From: Sue Howell
Sent: 07 October 2014 16:55
To: Planning.Responses
Cc: Simon Davis
Subject: RE: Planning Consultation on EG/77/14/DOC

APPLICATION NO: EG/77/14/DOC

Site Address: Tars Farm Church Lane Barnham PO22 0DB

Description of Works: Application for approval of details reserved by condition 3 (trees/shrubs) relating to planning application EG/64/12/

Proposal

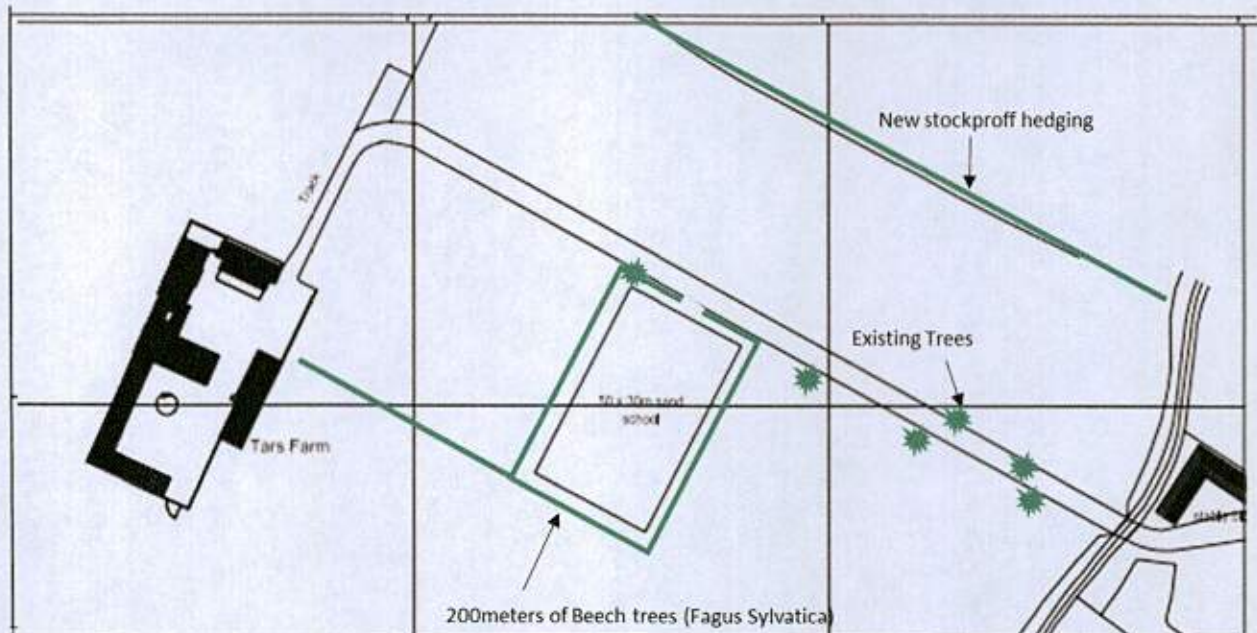
As a condition of application EG/64/12 details development permitted shall not be carried out until a full landscape scheme has been submitted for approval, detailing species choice, position, densities and size at time of planting. This should be plotted and submitted in plan and list form (**not just indicative**) and in relation to the trees and vegetation to be retained in the locale, so that a clear picture of the proposals can be seen. These details are required to assure the adjacent land setting is maintained, the setting is uncompromised and the proposals are appropriate for setting.

The condition also details that on approval of the proposed scheme, the permitted development shall not be carried out until the proposed is planted to the boundary of the ménage and/or to reinstate the former field boundaries suggested in point 4.3 of the phase 1 Habitat Survey.

We would also advise that Ash - Fraxinus species are omitted from the species mix proposed due to recently reported Ash dieback Chalara fraxinea reported within the UK.

We would not recommend the discharge of Condition 4 until the above has been approved and implemented.
